DEVELOPMENT REVIEW BOARD  
TRANSPORTATION DEVELOPMENT

DRB Project Number: 1011507  
Luke Subdivision

SUBJECT: Preliminary/ Final Plat

Application Number: 18DRB-70122

Plat for
Lots 10-A and 11-A, Block B
 Being Comprised of
Lots 10 and 11, Block B
Luke Subdivision
 City of Albuquerque
 Bernalillo County, New Mexico
 April 2018

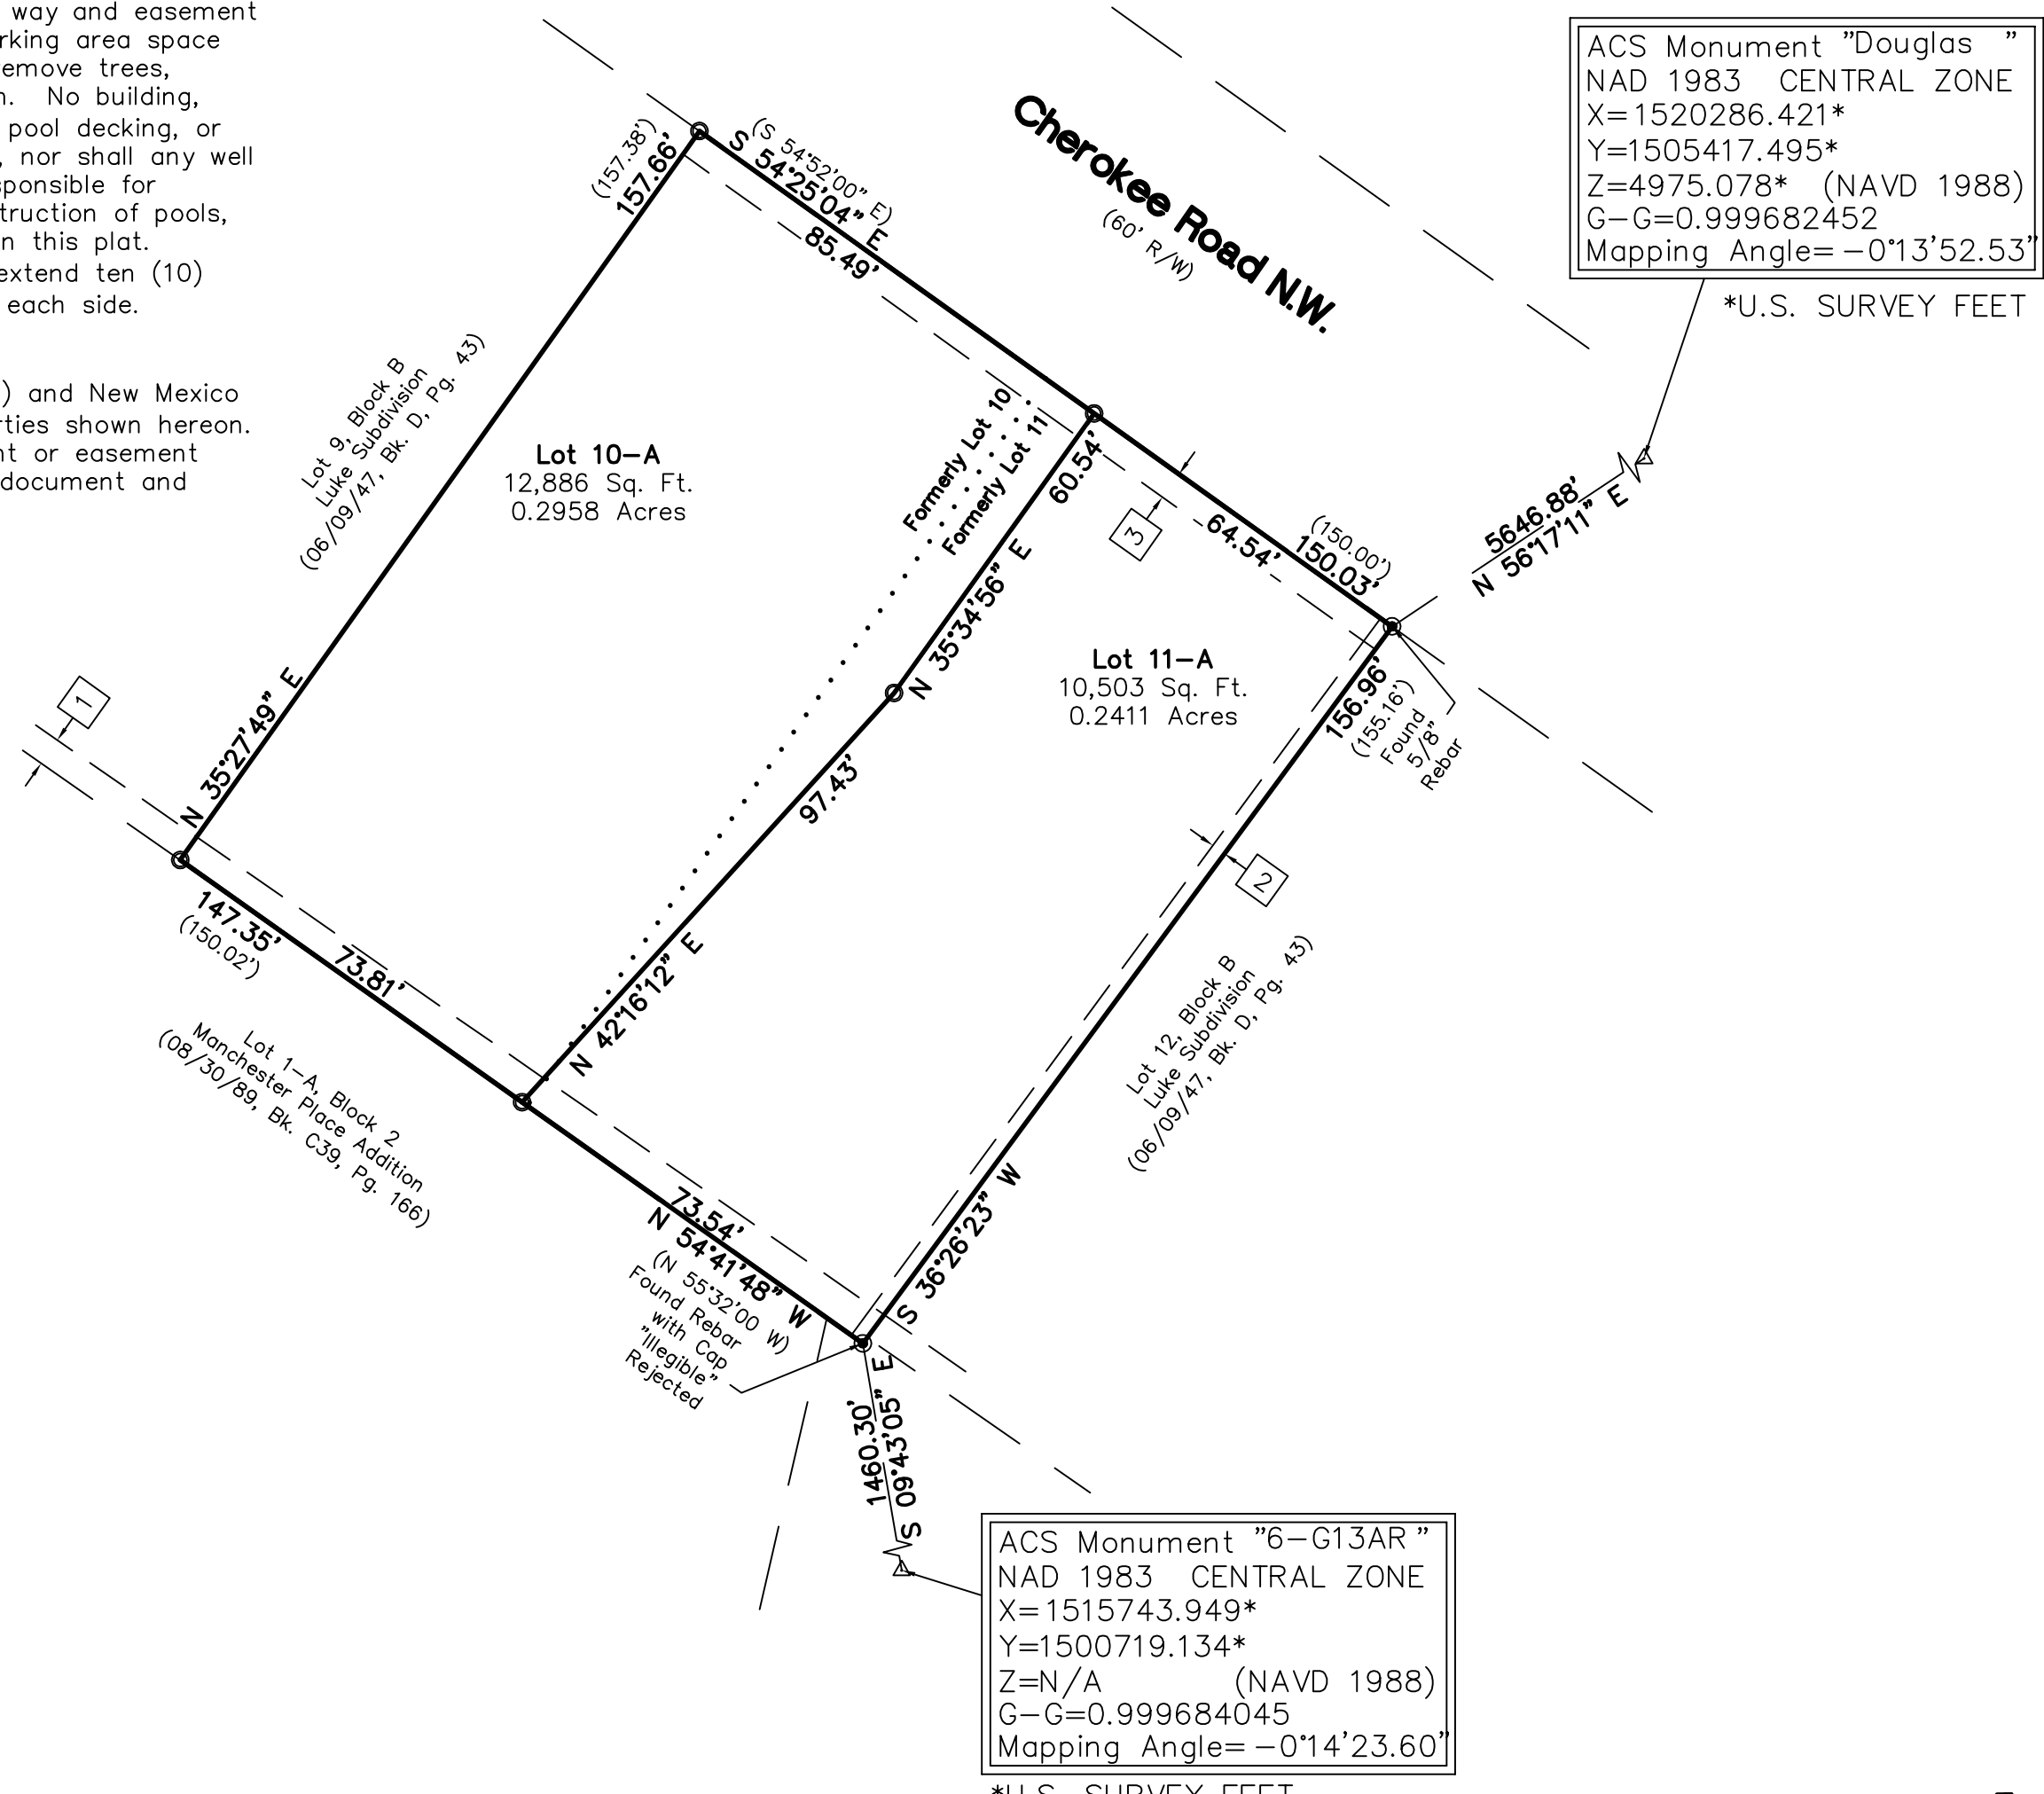
*on neighbor's prop*

1. It appears a wall is located in the right of way. A revocable permit is needed; please contact Jeanne Wolfenbarger (924-3992) for more information.
2. The driveways need to be shown on the site sketch. It looks like they may be shared by the two lots so an access easement may be required. Please verify the location of the driveways.
